Consultation Response from: KC Environmental Health (Pollution & Noise Control)		
2025/93517 - Flockton Green Working Mens Club, Barnsley Road, Flockton, Huddersfield, WF4 4AA		
Discharge of conditions 7 (intrusive investigation), 9 (Phase I Desk Study Report), 10 (Phase II Intrusive Site Investigation Report), 11 (Remediation Strategy), 12 (Preliminary Risk Assessment), 13 (Verification Report), 14 (Noise), 16 (car park) on previous permission 2025/91797 for removal of condition 16 (car park use) on previous permission 2024/90153 for change of use of dwelling to Working Mens Club, erection of single storey extensions, formation of raised patio to rear, side and front, with improved disabled ramp access to front, external render and associated external alterations		
Responding Date: 12 January 2026	Responding Officer: SR/MN	Responding Ref: WK202540984
<p><u>Comments</u></p> <p><u>Condition 9 (Phase I Desk Study Report)</u></p> <p>In support of the discharge of condition 9, a Preliminary Investigation by G&M Consulting Ltd, ref: C762, dated November 2025 has been submitted. The report contains geotechnical information, which is beyond the remit of Environmental Health. This response

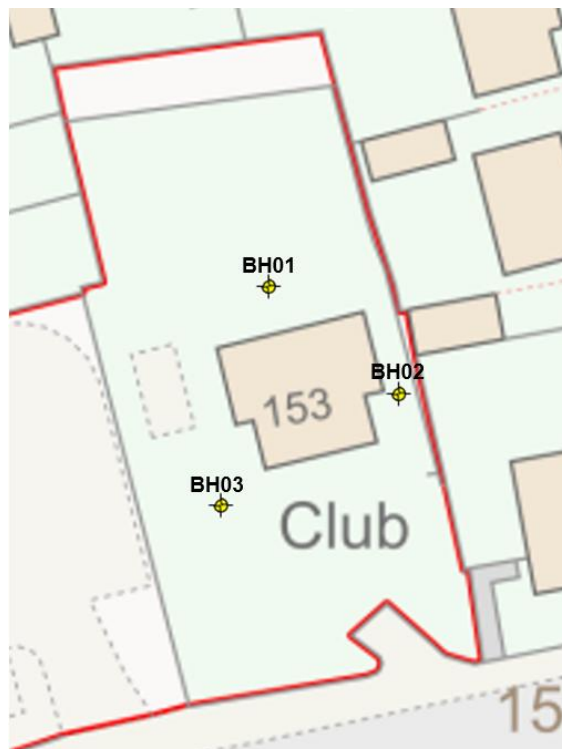
completion. Driller records indicate likely shallow workings as 'void lost water returns' in boreholes BH01 and BH03 at depths of between 7.4 and 7.7 m bgl and up to 1.2 m in thickness were observed. Coal was recorded in BH02 between 7.5 m and 8.6 m bgl. Voids and shallow coal have been confirmed at site.

The report goes on to discuss drilling and grouting which is geotechnical in nature and beyond the remit of Environmental Health. The report does not offer a revision of the conceptual site model or opinion on risk associated with potential mine gas at site.

This report is not a Phase II Report and whilst it provides information, it cannot be accepted at this time.

We do not accept the letter by G&M Consulting Ltd, dated the 10th of June 2025, ref C753/01/ATS, which details an intrusive mining investigation by Cape Site Services Ltd. Therefore, condition 10 must remain.
